OUT18/1989

**Borg Panels Timber Processing Facility (SSD 7016 MOD 1)  
Comment on the Statement of Environmental Effects (SEE)**

Alex King  
**Director Cabinet and Legislation Services**  
15 February 2018

Drawing
SURFACE WATER MANAGEMENT
SYSTEM

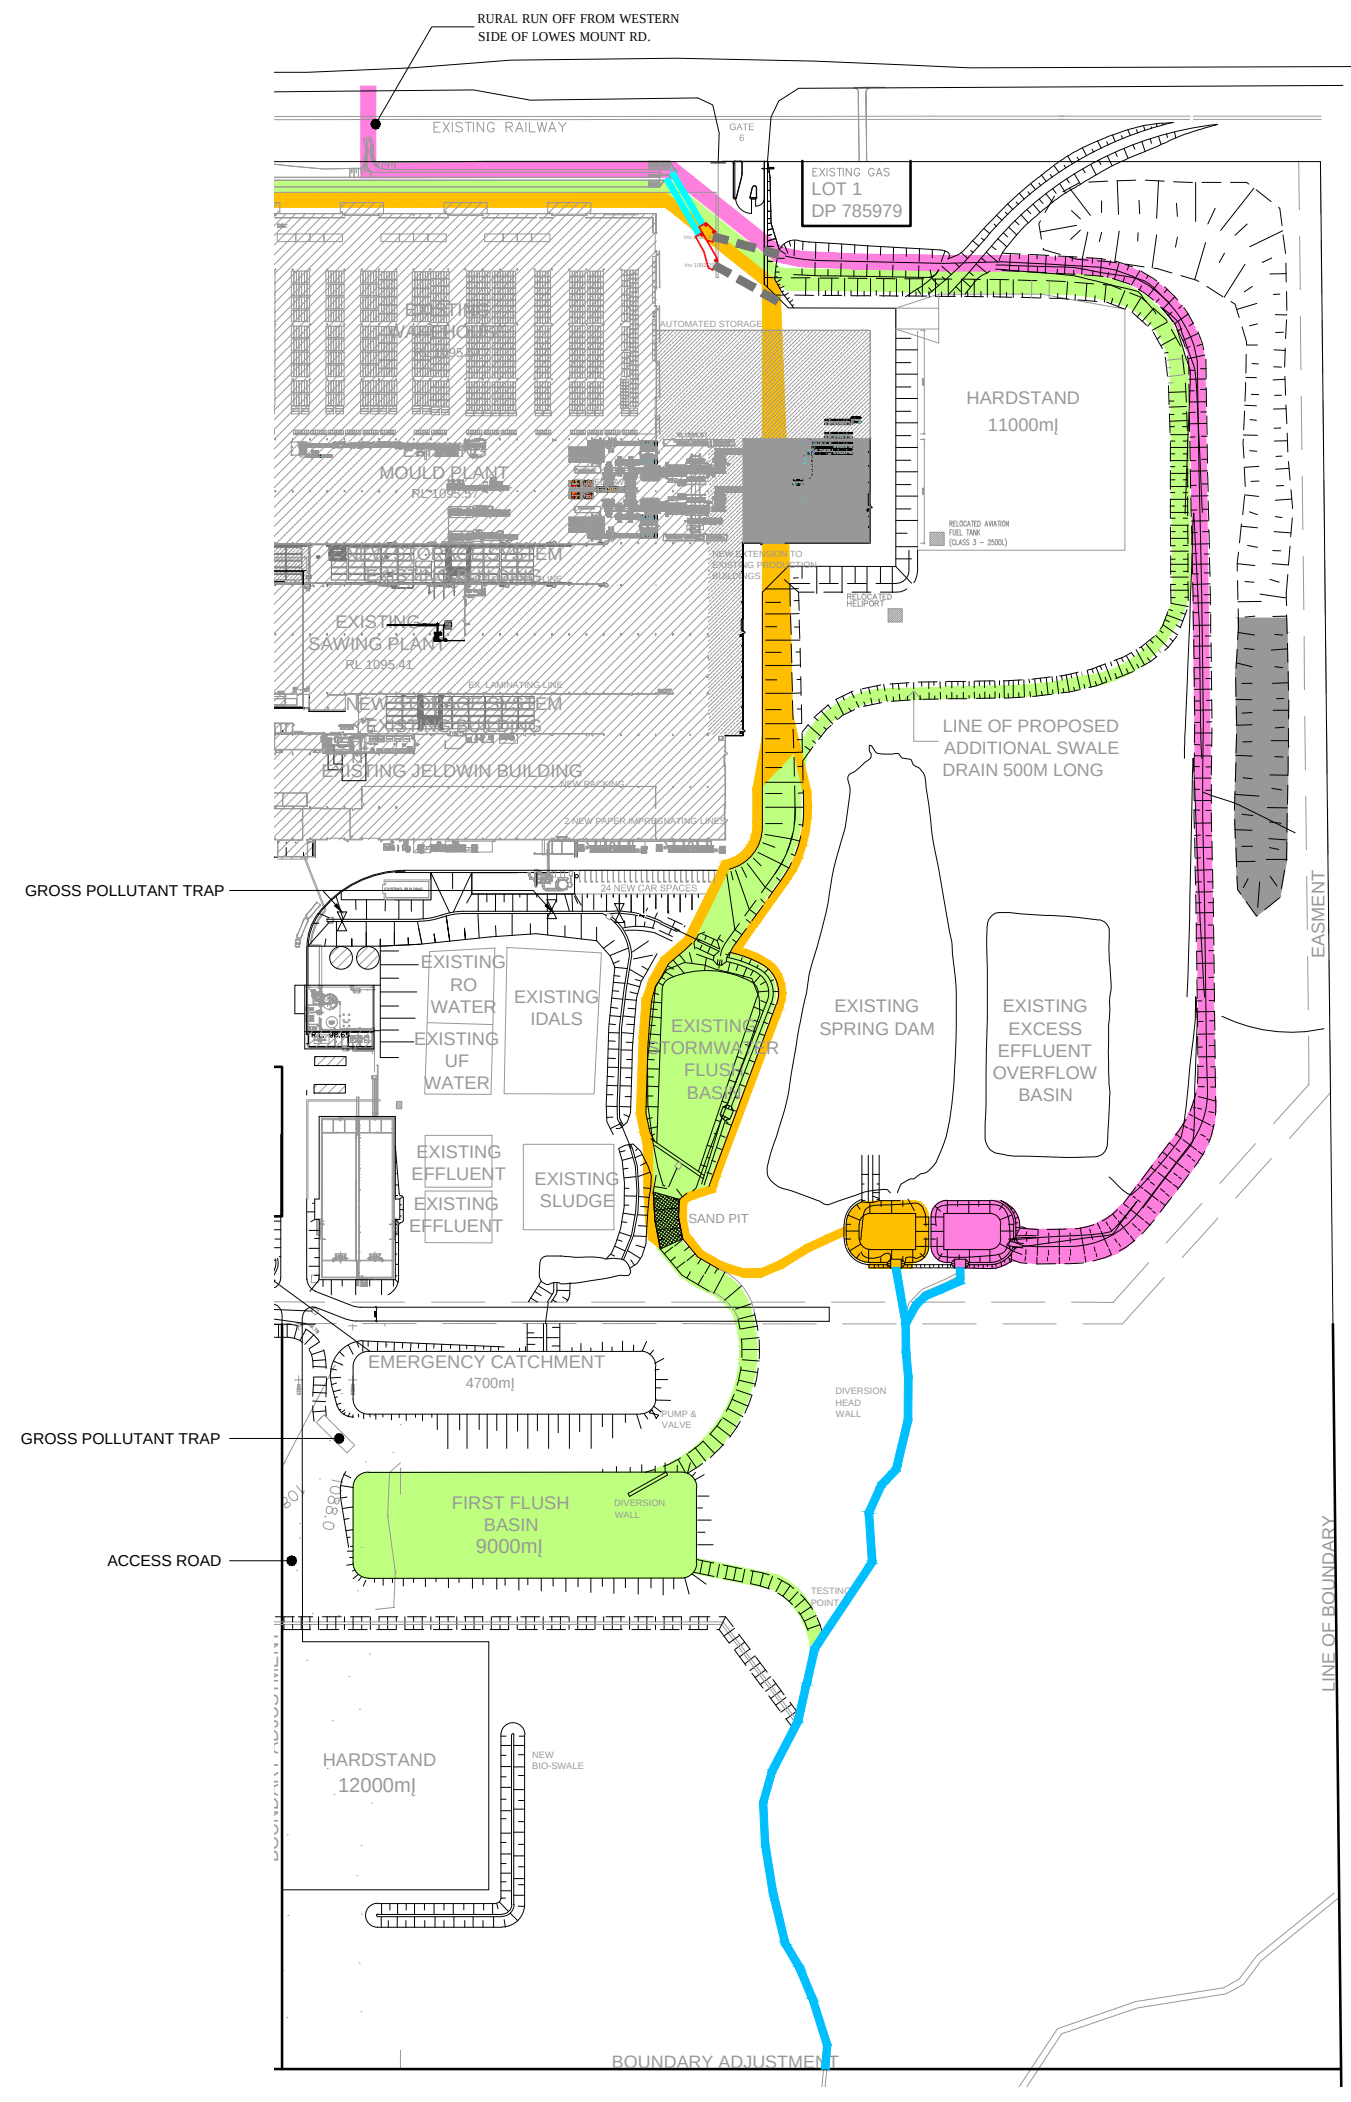
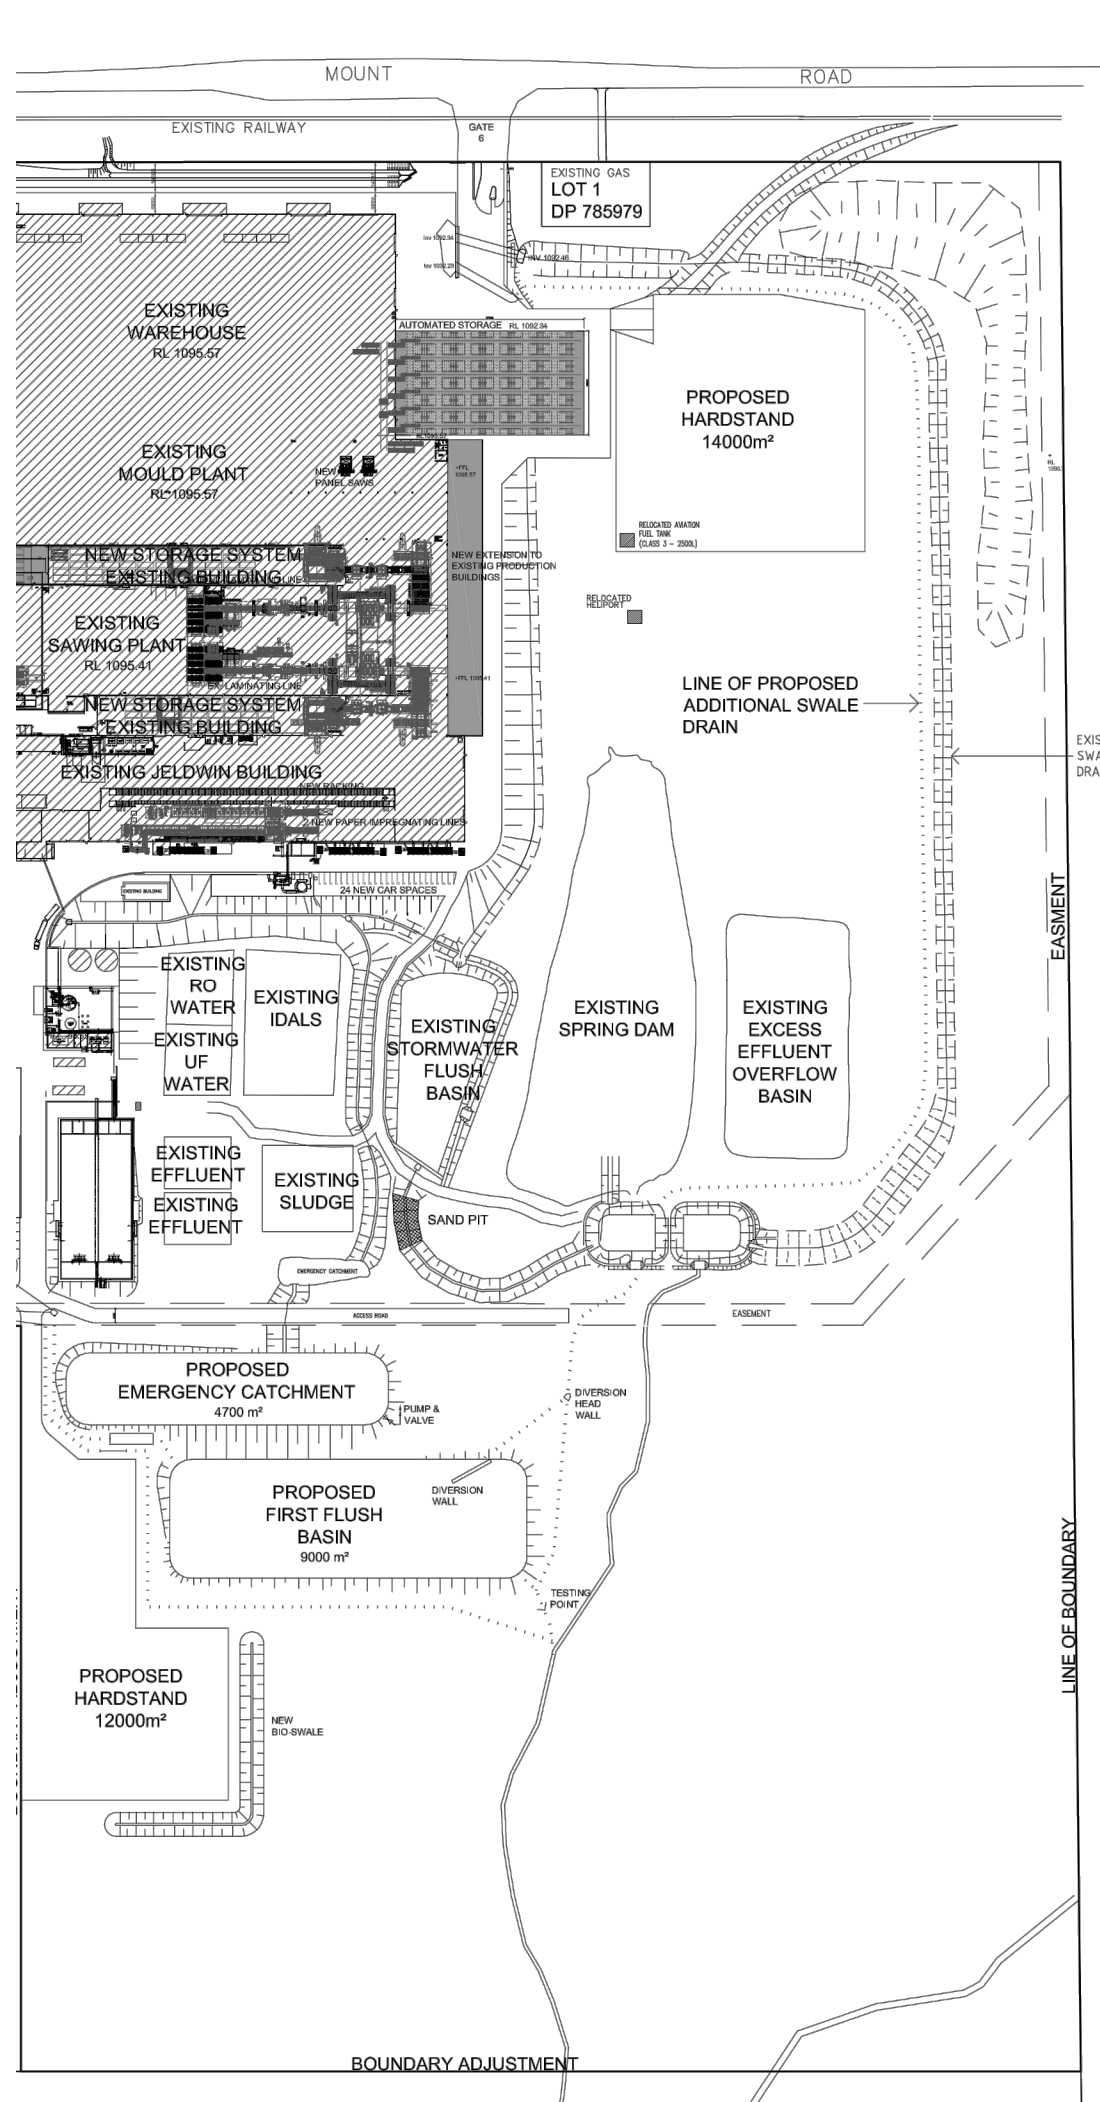
- The proponent should clarify whether the proposed diversion of water into the stormwater treatment pond will result in a change to the water balance at the site. Should this result in an increase in water extractions from the stormwater treatment pond and a reduction in discharge from the site any reductions will need to be considered in terms of impacts to downstream users and the environment.

- The proponent must provide notification to Crown Lands of any uncontrolled discharge from the 'First flush basin' to the unnamed creek that discharges to Kings Stockyard Creek.
